Subject: Geotechnical Engineering Addendum, Residence Remodel and Addition,
5425 W. Mercer Way, Mercer Island, Washington.

Reference: Geotechnical Engineering Study, Proposed Addition, 5425 West Mercer Way,
Mercer Island, Washington. GEO Group Northwest, Inc., May 20, 2023.

GEO Group Northwest, Inc. has prepared this addendum to our above-referenced geotechnical engineering report regarding the proposed residential remodel and addition project at the above-subject location on Mercer Island, Washington. This addendum presents our responses to the geotechnical peer review comments posted to the submitted plans site via the City of Mercer Island permit portal, and geotechnical comments provided in the review letter by Kolke Consulting Group, Inc. dated September 23, 2023.

S3.0

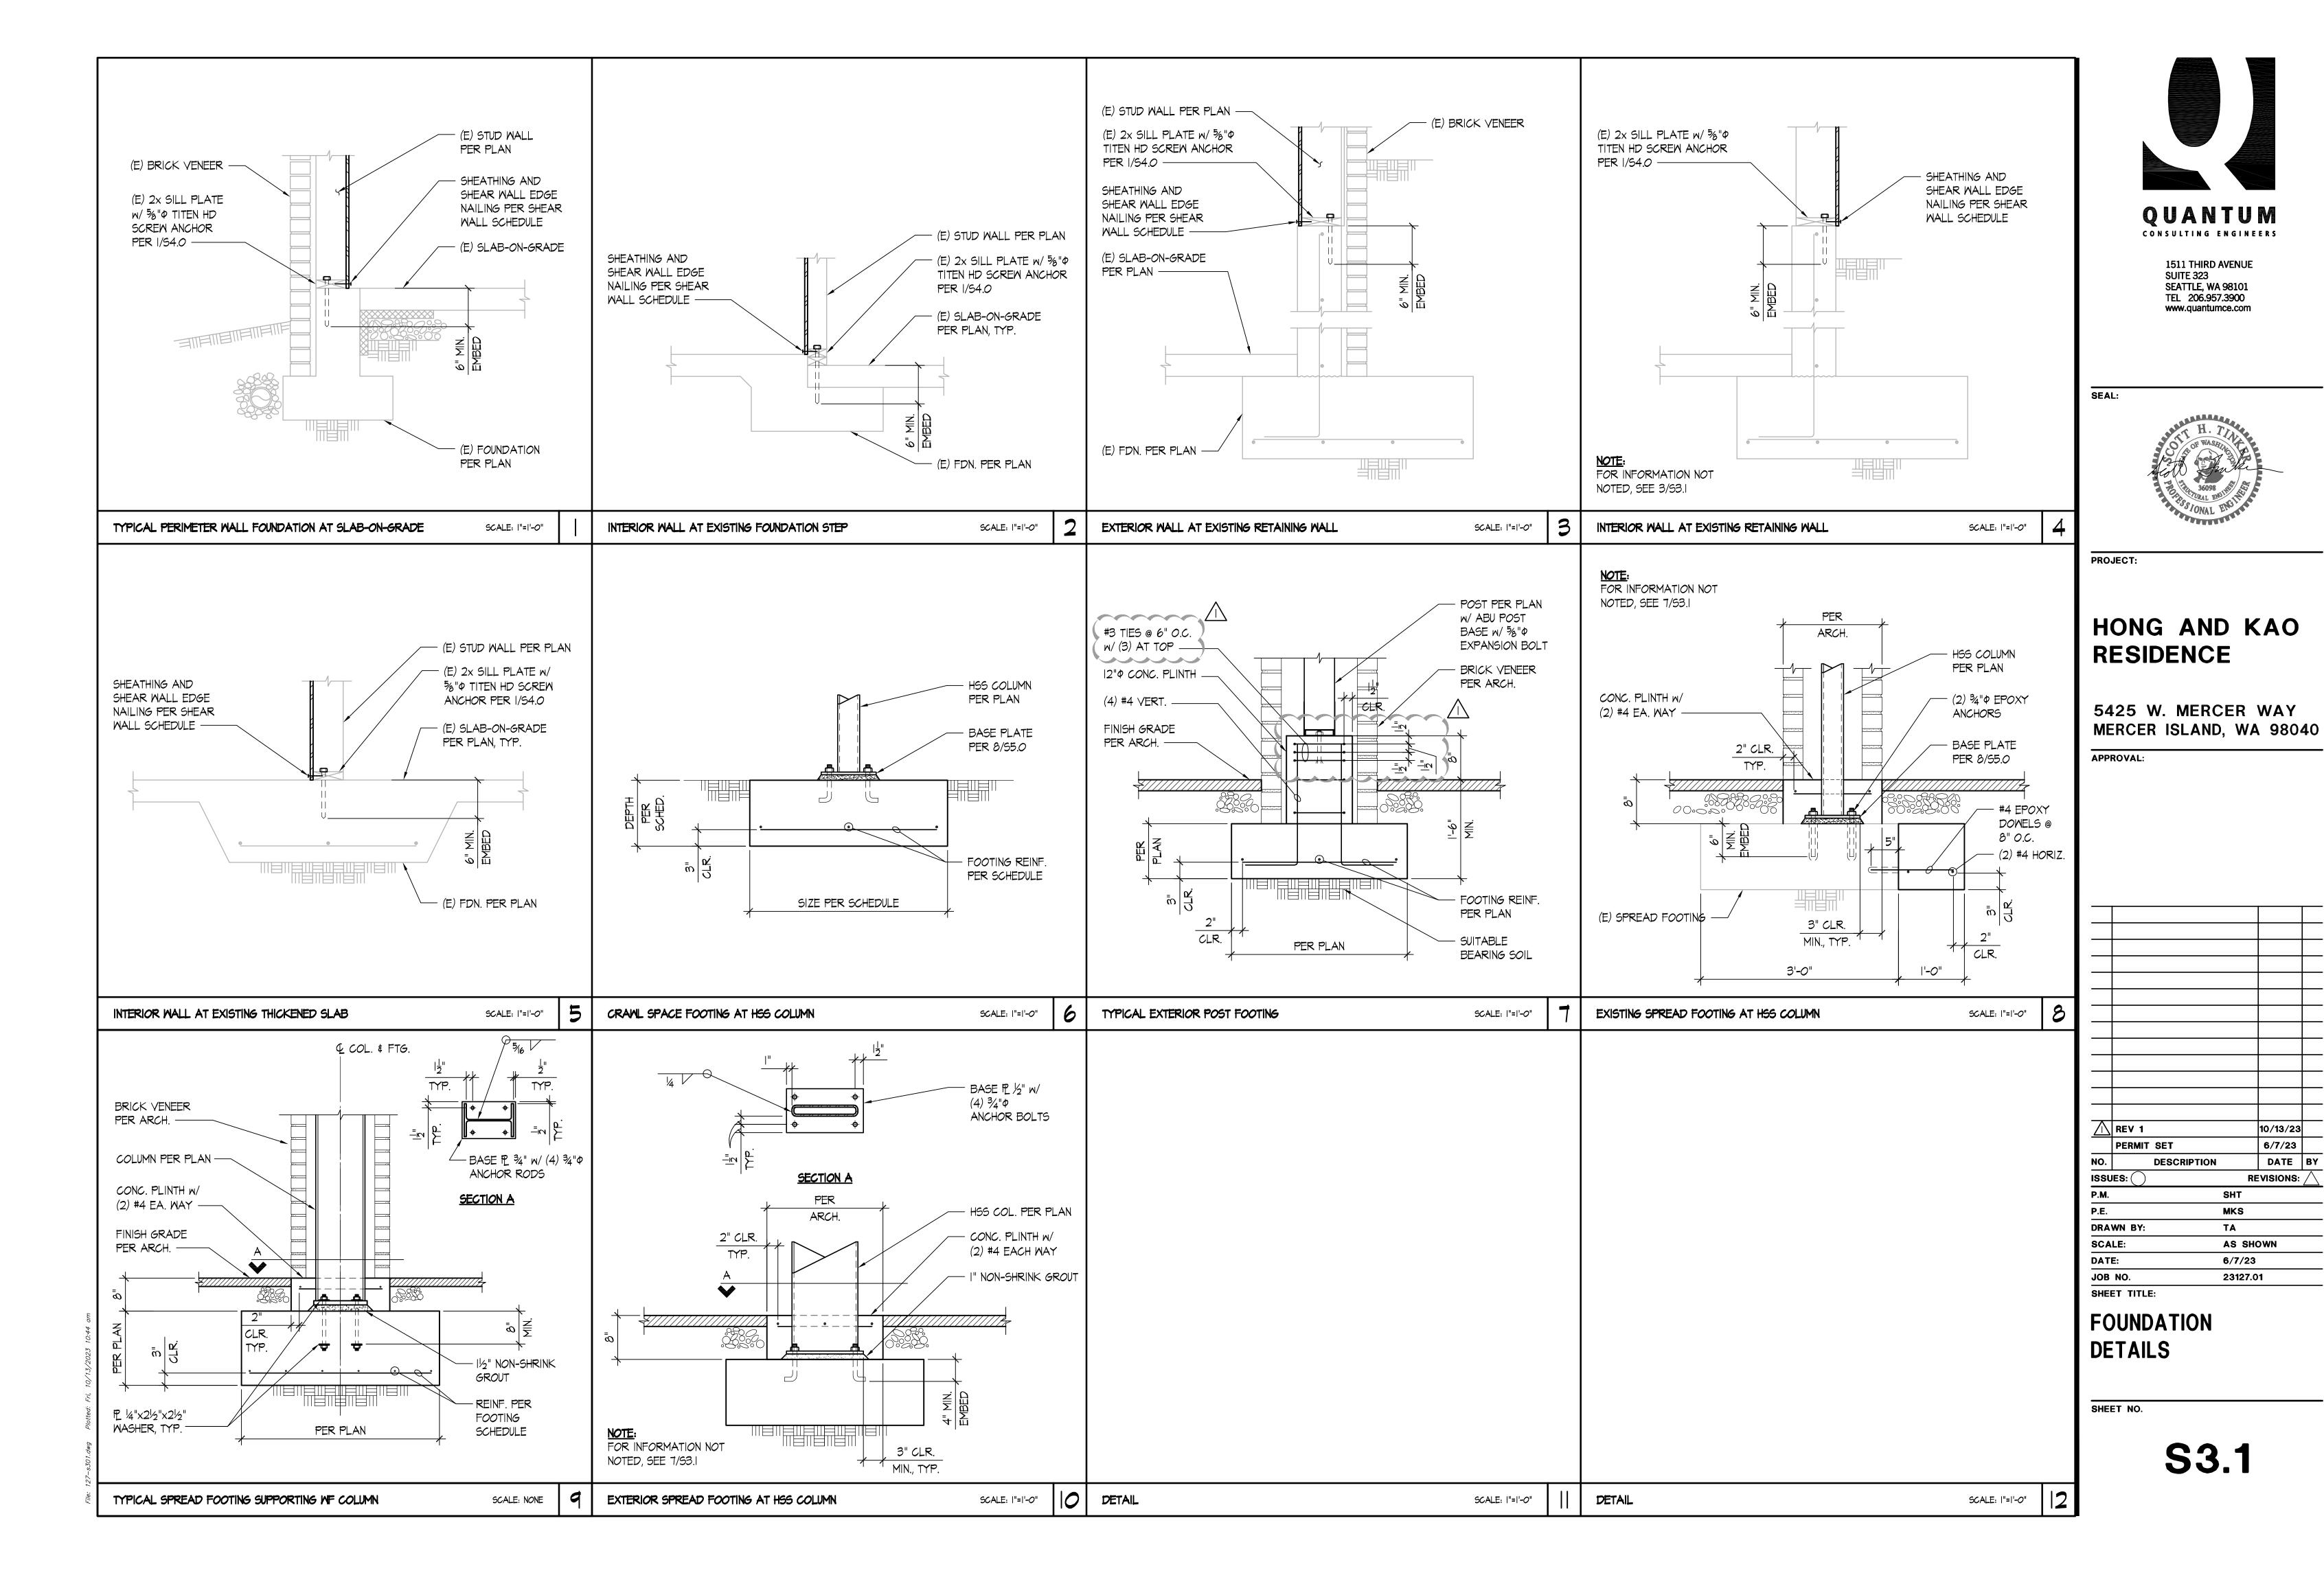
We have reviewed the location and depth of the proposed new footing inside the footprint of the existing residence as shown in Sheet 6.1, Section 2 and specified in Sheet S3.0, Detail 12 and Sheet S3.1, Detail 6. We have noted that the grade inclination in the area around the footing is approximately 2H:1V. Soils found in boring B-1 completed near the existing residence during our geotechnical study were observed to consist of medium dense / very stiff silt from near-surface depths to the bottom of the boring at a depth of approximately 26 feet.

We conclude that the vertical and lateral extent of loading imposed by the footing does not intersect with nearby existing footings or vice versa. Also, we anticipate that excavation work to construct the footings can be performed without removing support for nearby existing footings.

Based on these considerations, it is our opinion that the depth, location, and allowable loading from the proposed footing are acceptable from a geotechnical perspective provided that the proposed footing is directly supported on medium dense or stronger native soils and at a minimum depth of 18 inches below lowest adjacent grade, and verified during construction.
